DOLWENDEE QUARRY

Biodiversity and Rehabilitation Management Plan

May 2021

Figure 11: Conceptual rehabilitation plan

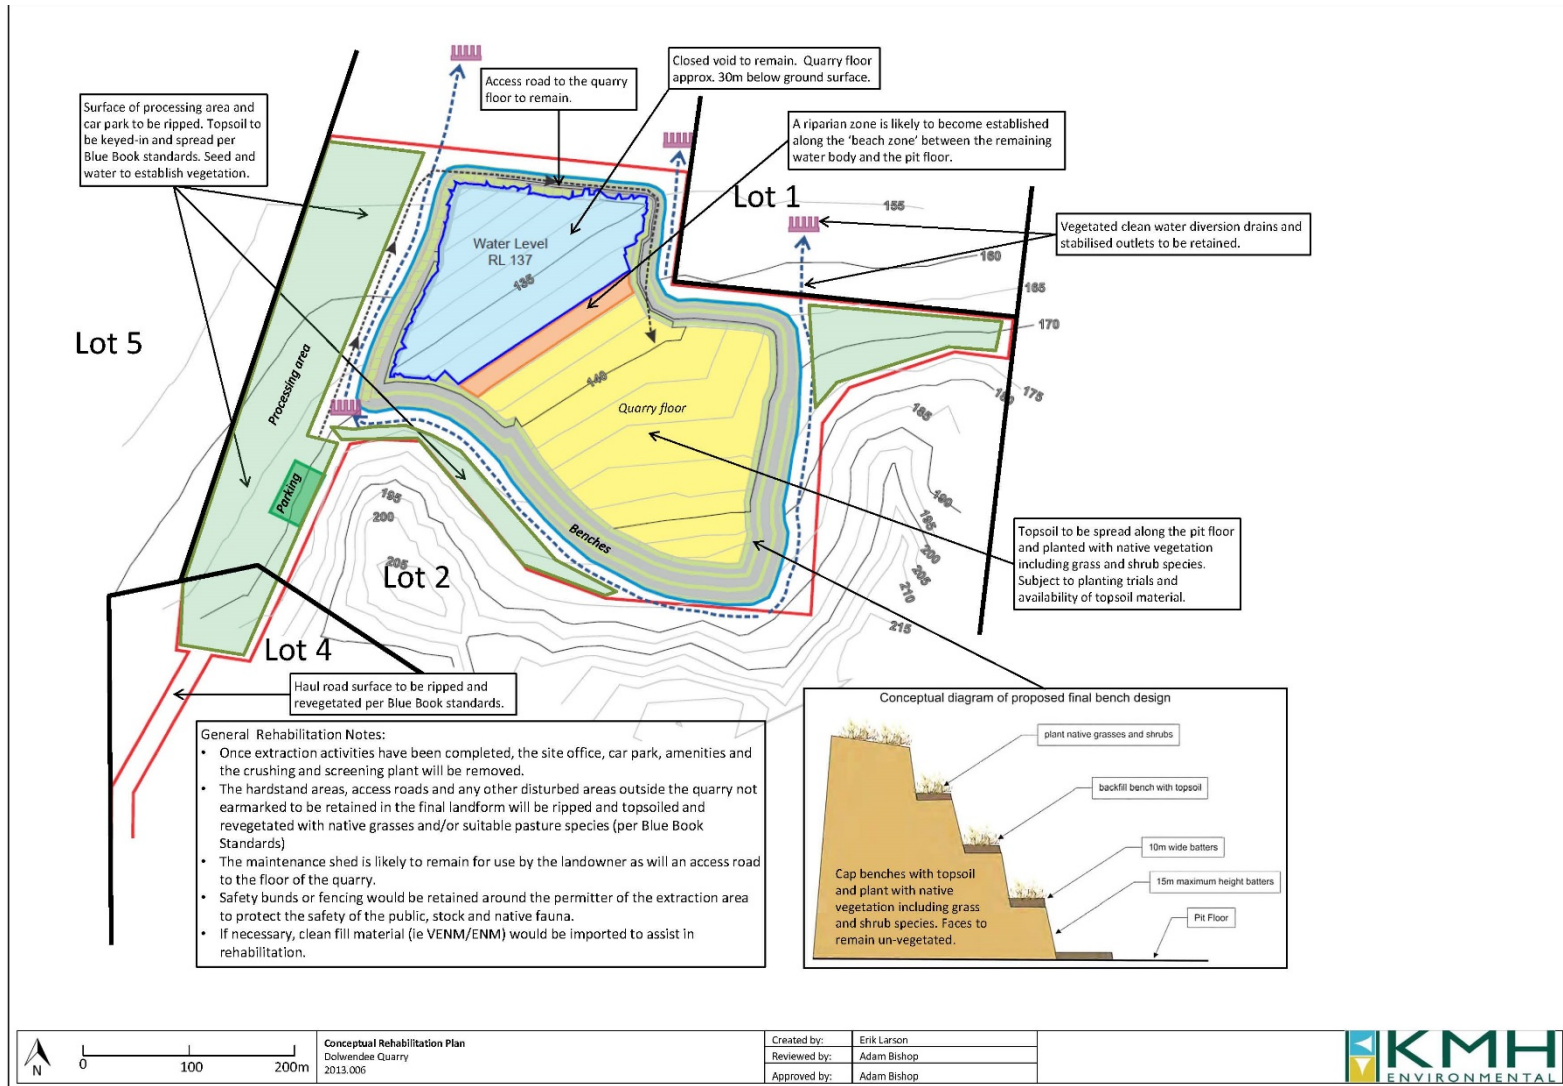
<p>• Ensure all recommendations from BCD's review have been adequately addressed. For example, the response to BCD – R3 still does not demonstrate integration of rehabilitation and the Biodiversity Offset (see comments regarding condition 31(d), Schedule 3), and the figures referred to in BCD – R13 are still grainy and difficult to read even though they have been reinserted as JPEG files.</p>	<p>Disagree – refer to response to Condition 31(d).</p> <p>Disagree - BCD comments may be true but DPIE did not raise this issue prior. Consent doesn't require final BRMP to be submitted to BCD. Regardless, clear figure attached.</p>	Figure 4 reinserted.
